**KIRKLEES METROPOLITAN COUNCIL
INVESTMENT & REGENERATION SERVICE**

Reference No: 2020/62/91370/E

Site Address: 245, Roberttown Lane, Roberttown, Liversedge,
WF15 7LJ

Description: Erection of extensions, dormer window to rear,
demolition of existing garage and external alterations

Proposed Front Elevation 1:50

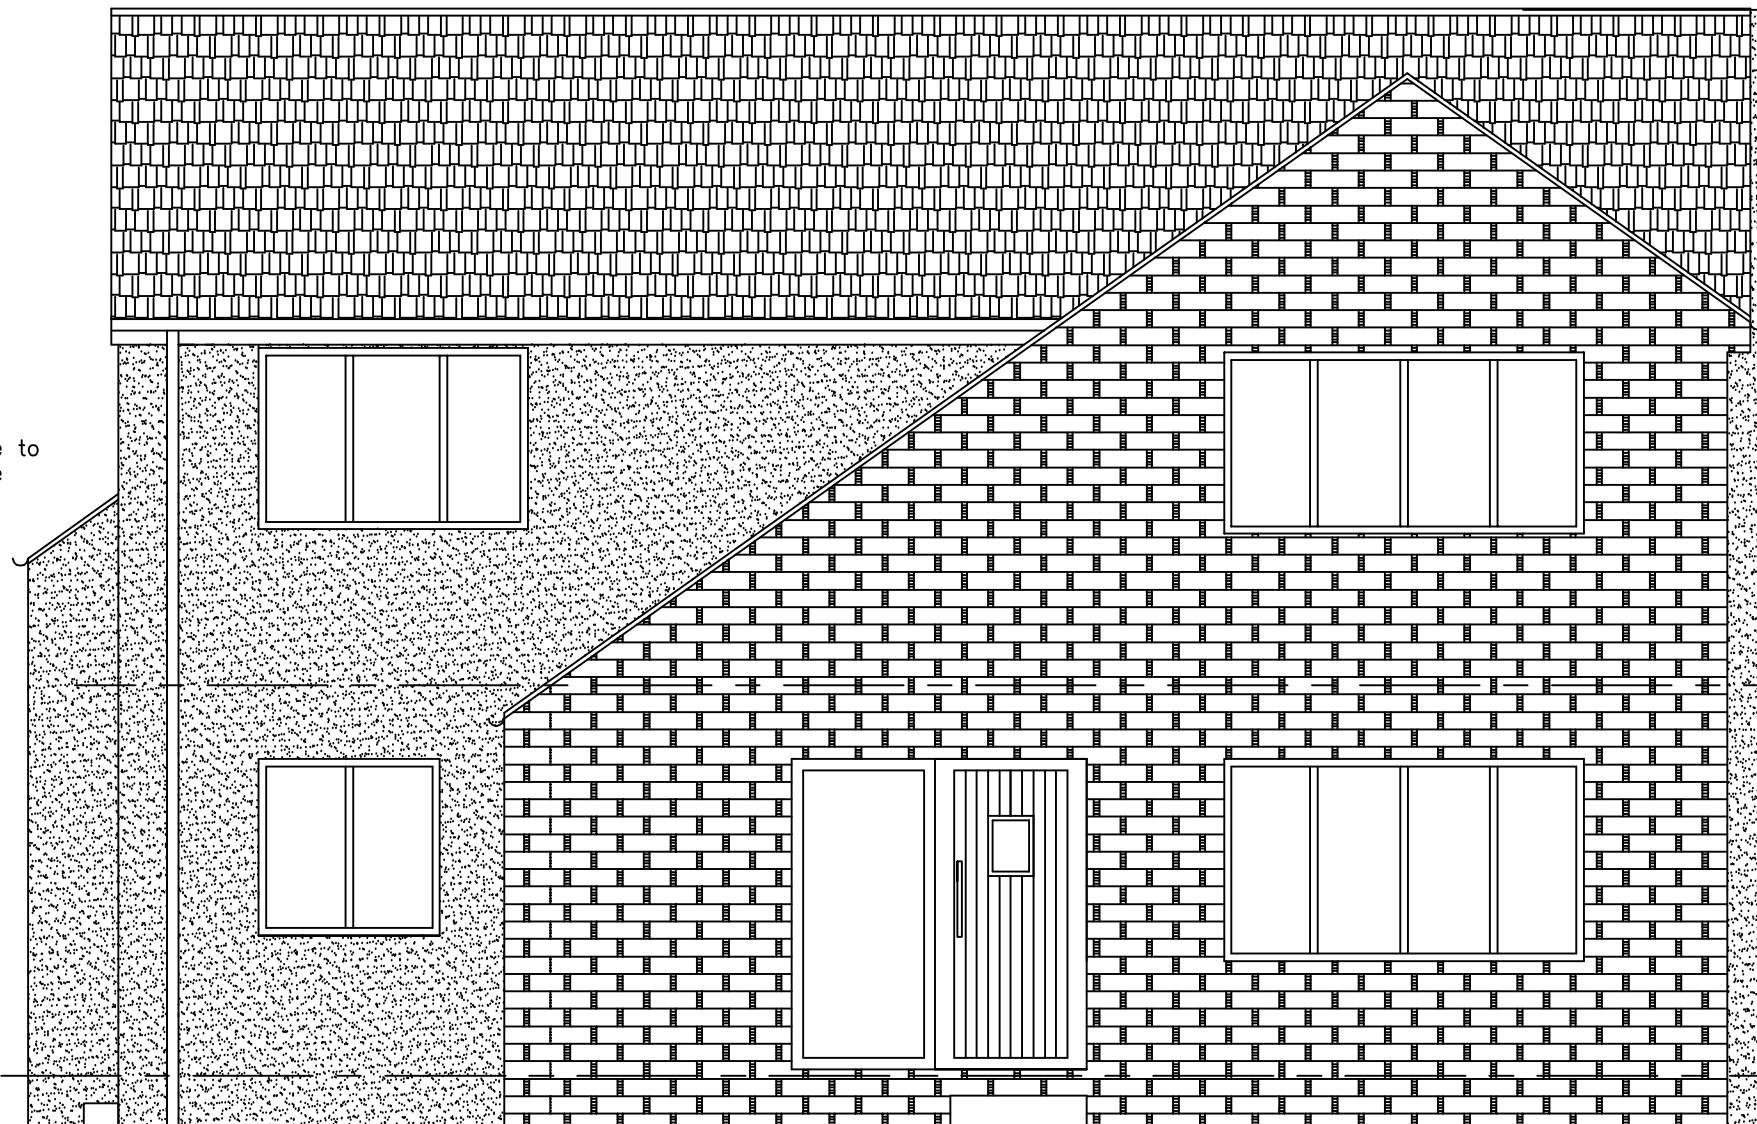
Change to the external materials – The proposed description of development refers to external alterations – this includes a change to the materials of the existing dwelling. As indicated on the plan, part of the existing elevation will be stone, with part constructed of white render. The rear elevation and side elevations will be constructed of white render.

Considering that there are a variety of materials within the wider area and the immediate context in which the dwelling will be read, the introduction of white render is acceptable, especially given that there are various examples of render within close proximity of the site, including 'The Star' pub which is sited in a prominent location.

The proposed materials, which are considered to complement one another, would not result in an overly prominent feature in the streetscene or would not detract from the character of the dwelling itself which does not have any particular architectural merit.

The front extension would sit flush with the front elevation of the main dwelling and would not project beyond the building line of the main dwelling. The roof form of the original part of the dwelling is replicated and there is no concern with regards to the host dwelling, street scene or character of the area.

Change to the proposed openings in the existing house – these openings are acceptable. The proposed materials, scale and design are acceptable in the context of the development and the extension will relate appropriately to the host dwelling in this regard.

3. As labelled on the submitted plans, the extension hereby approved shall be finished in white render for the external walls and blue artificial slate for the roof. The materials shall thereafter be retained as such.

4. As labelled on the submitted plans, the side and rear elevations of the host dwelling shall be finished in white render and retained as such. The roofing materials shall be artificial blue slate and retained as such.
